Response to WSCC comments December 2017.

**WEST SUSSEX COUNTY COUNCIL
PLANNING SERVICES CONSULTATION**

SUBJECT: LU/278/17/RES - Approval of Reserved Matters following Outline Permission LU/47/11 for Construction of the southern section of the Lyminster Bypass, including northern and southern roundabouts, surface water drainage and landscaping. Departure from the Development Plan & affects a Public Right of Way.

LOCATION: North Littlehampton Strategic Development Site, Land West of Toddington Park, Toddington Lane, Littlehampton, BN17 7PP.

LYMINSTER BYPASS - SOUTH
NORTH LITTLEHAMPTON
RECO WALLS (WSSC REF: 6078 & 6079)
GENERAL ARRANGEMENT

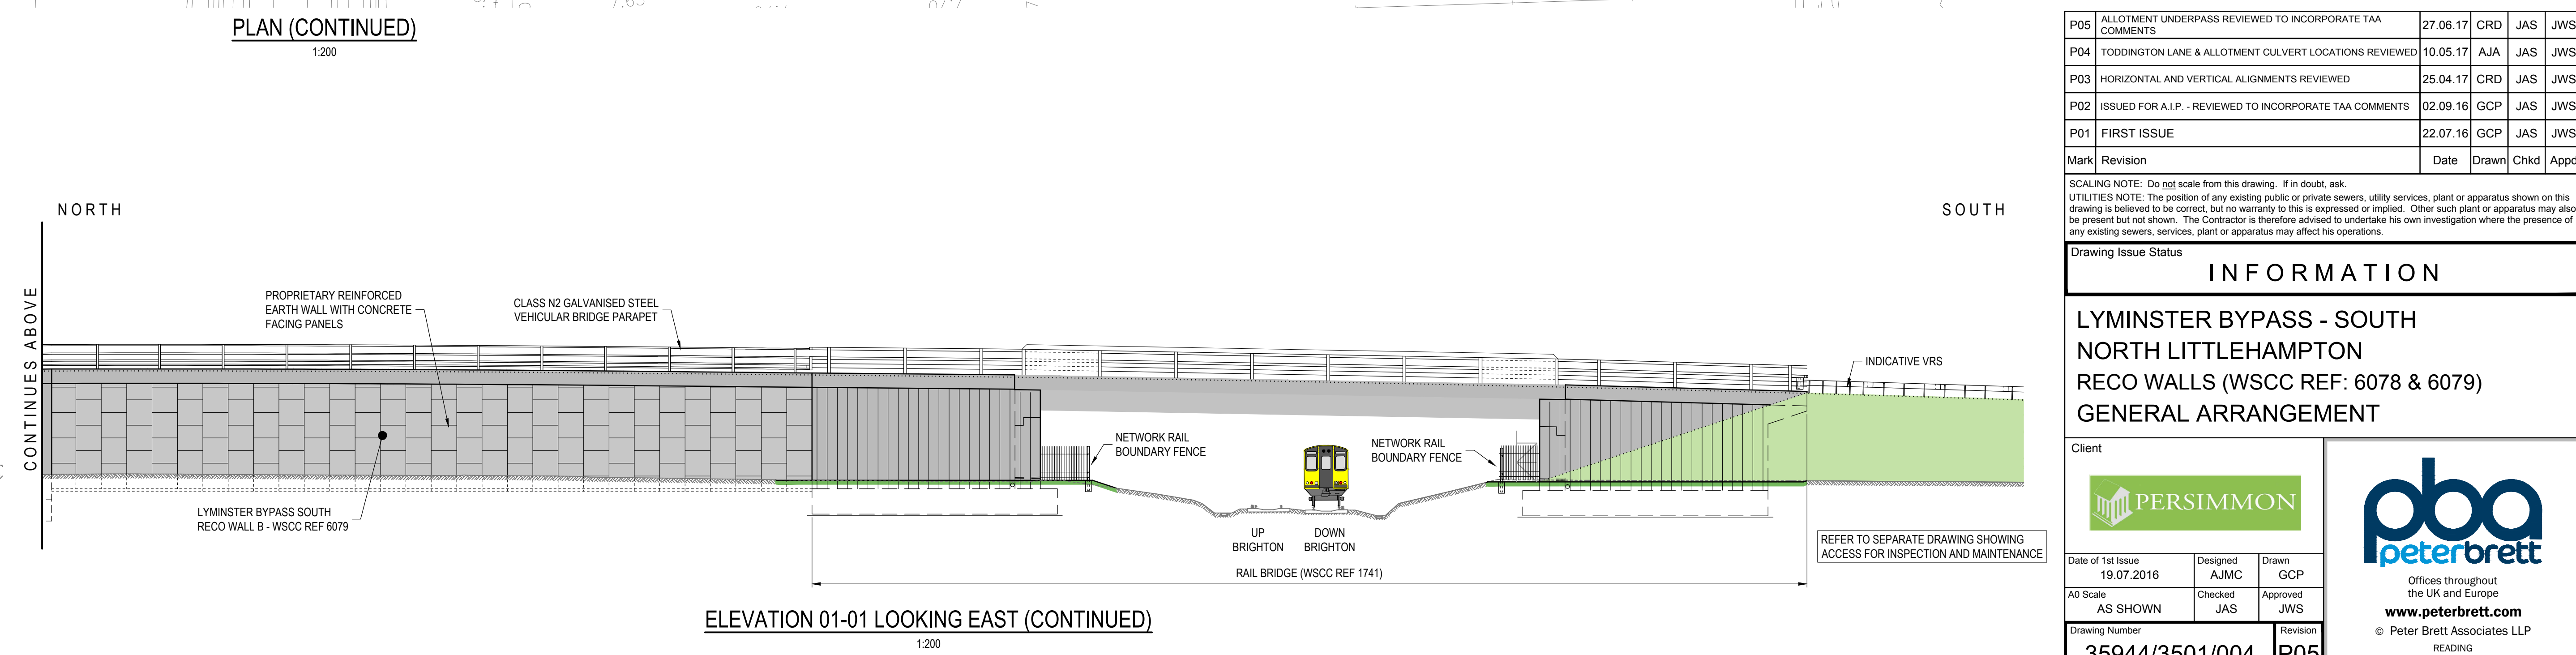
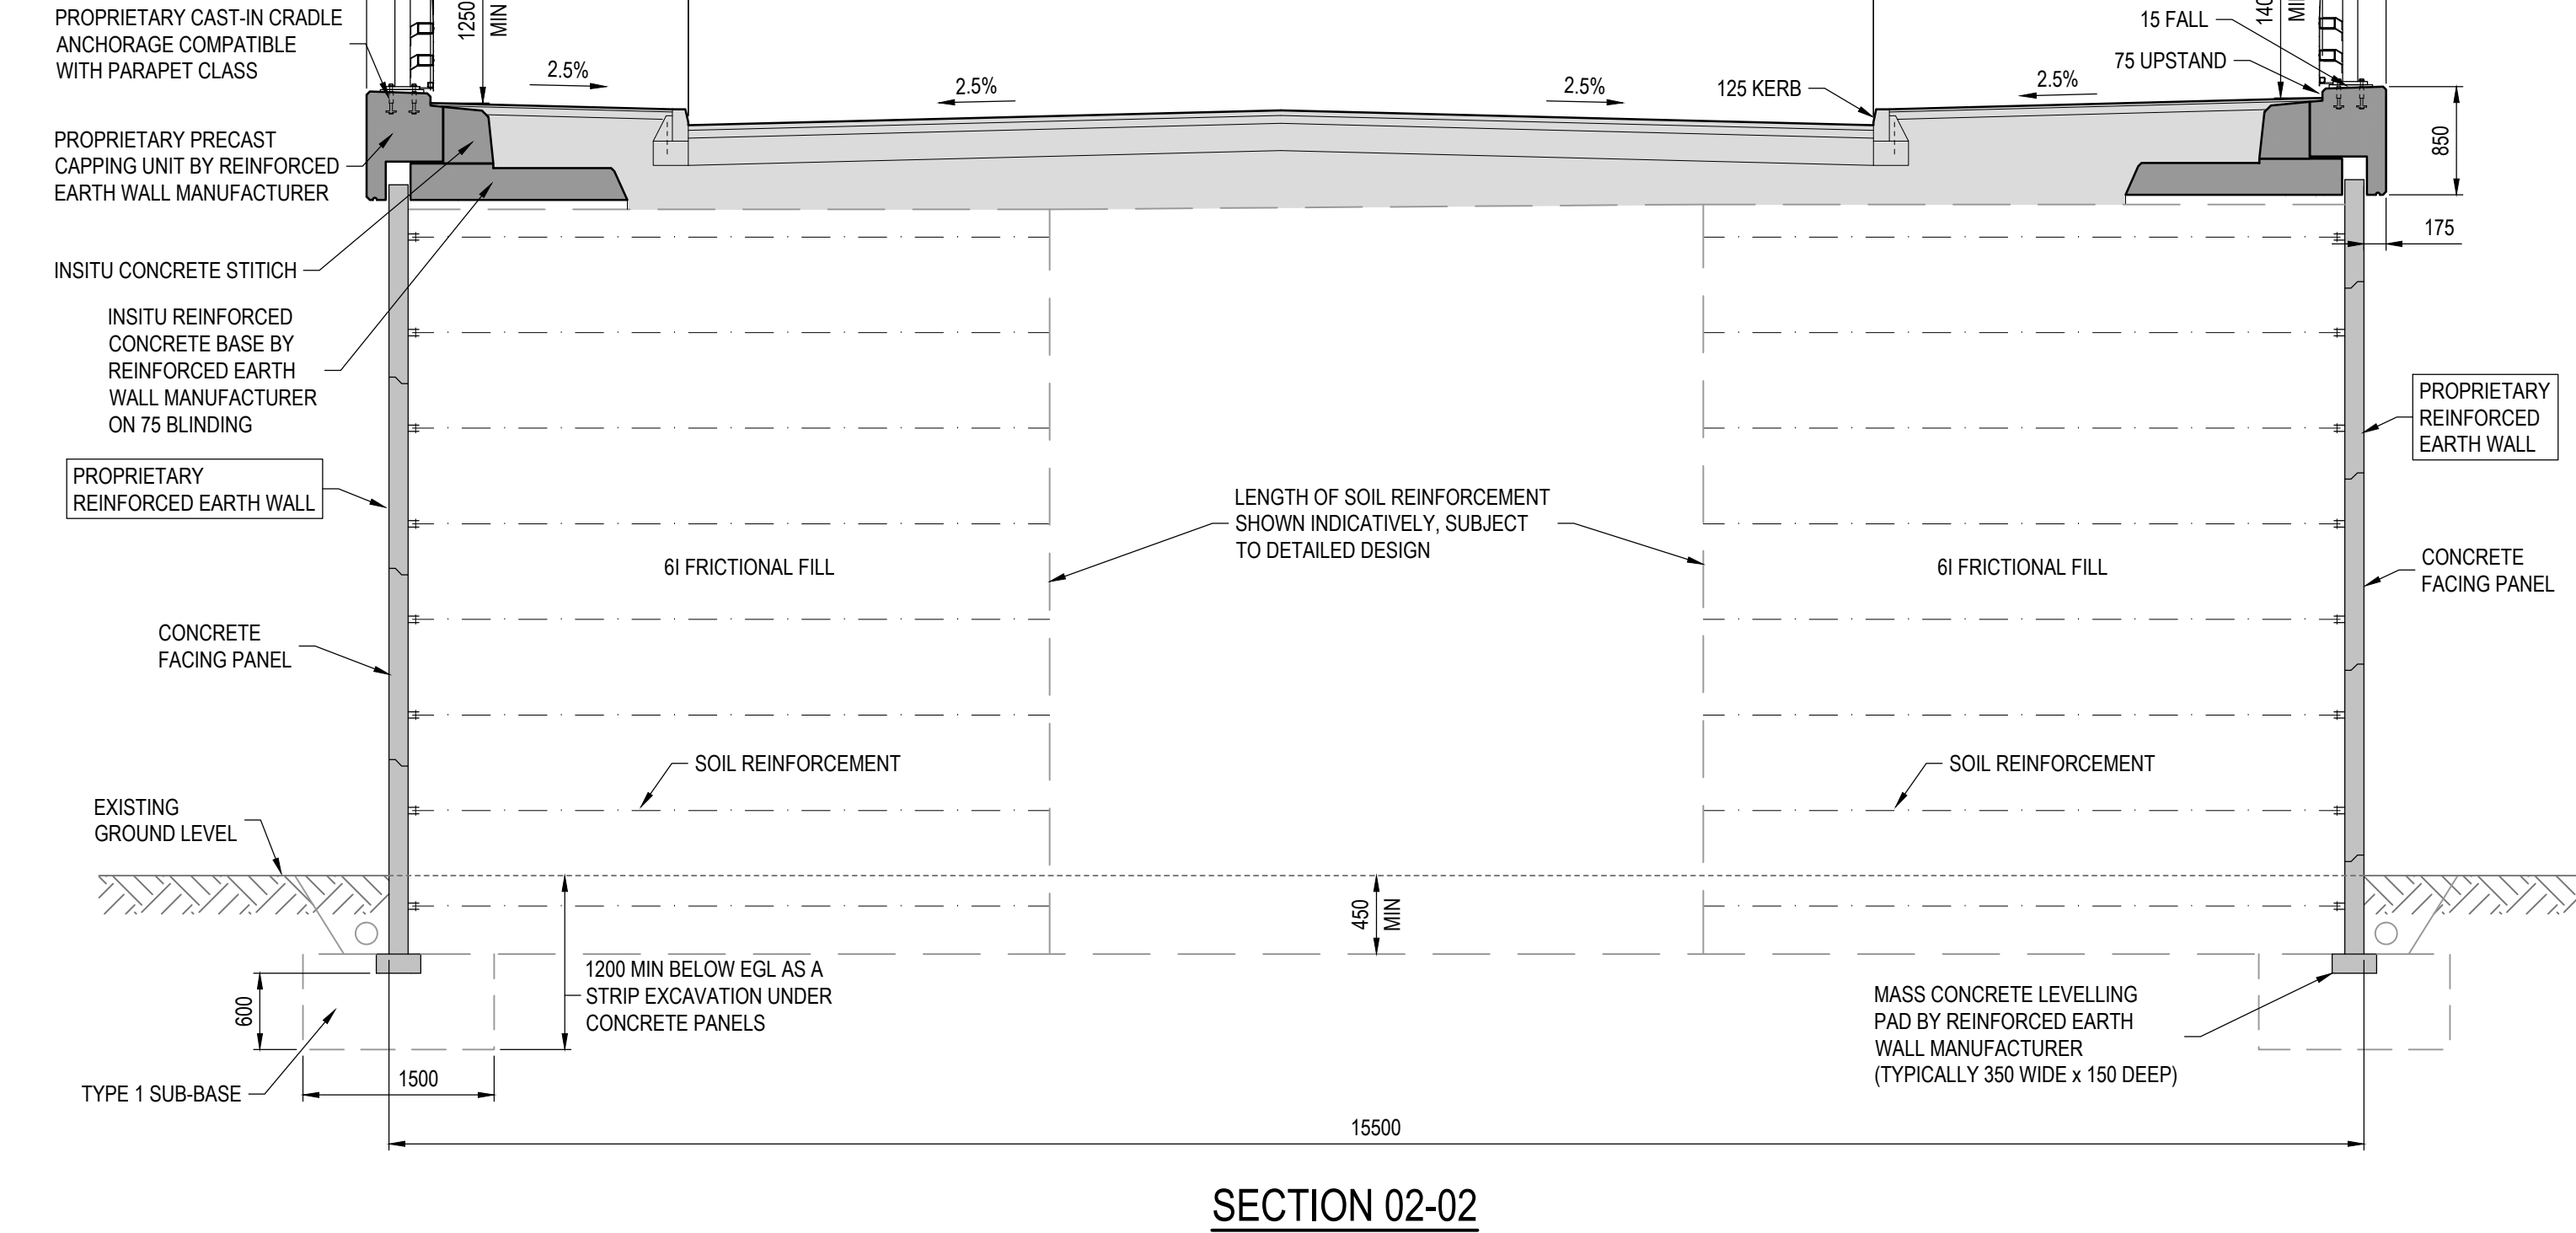
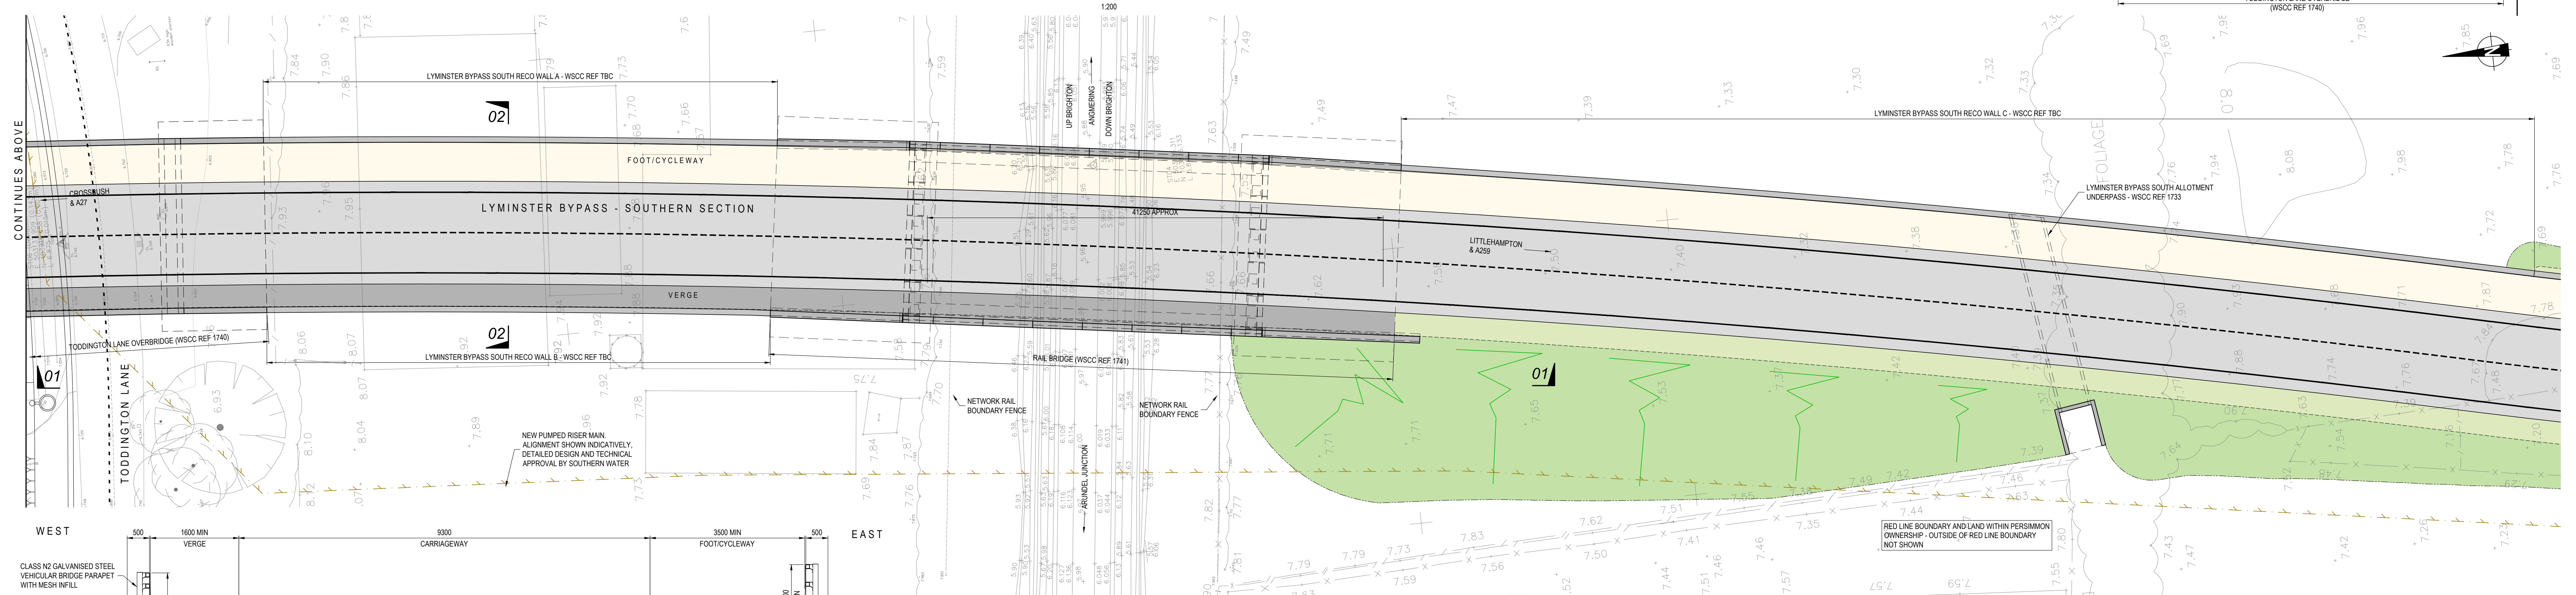
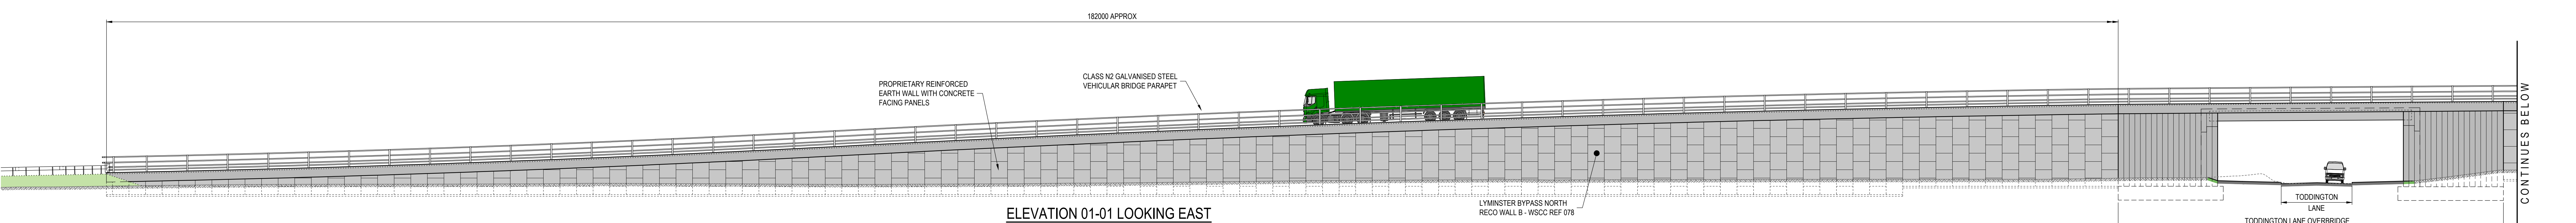
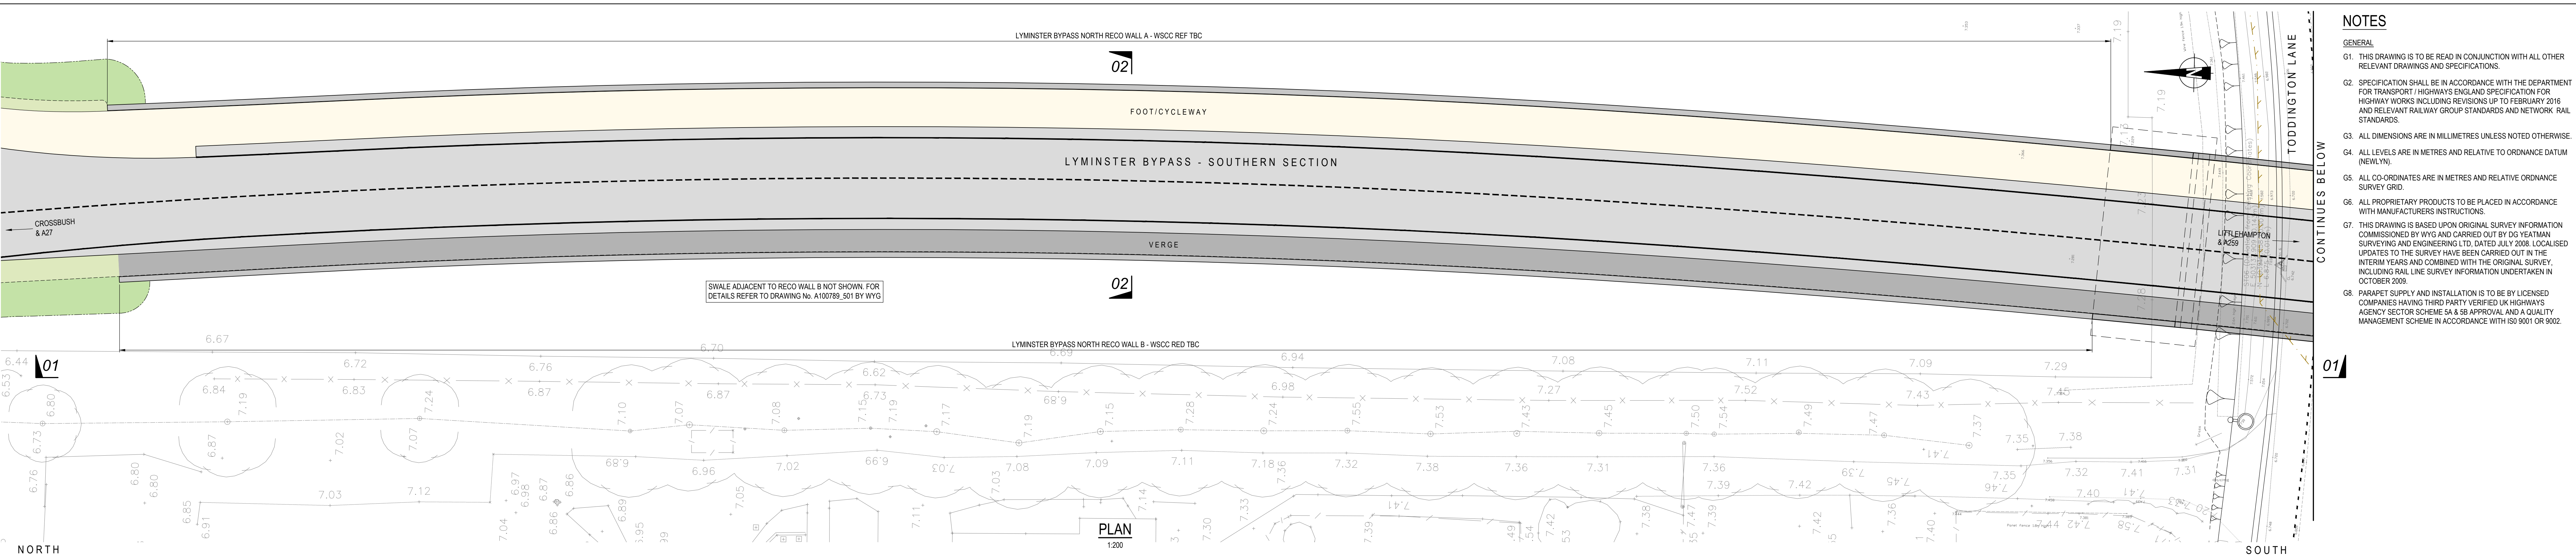
- AIP (bridge structures) – This is an ongoing process. WSCC's Structural Engineer has looked at the drawings on the Arun DC planning portal and the only one showing the bridges is Drg. No. 35944/3501/004 Rev P05. The current version of the same drawing that is on record here at WSCC that has been examined through the structures Technical Approval (TA) process is now Rev 6. At this stage, there do not appear to be any material changes that appear to affect the appearance when comparing drawing revisions. The Technical Approval process for the structures is, therefore, progressing and will continue to do so through the S38/278 stage.
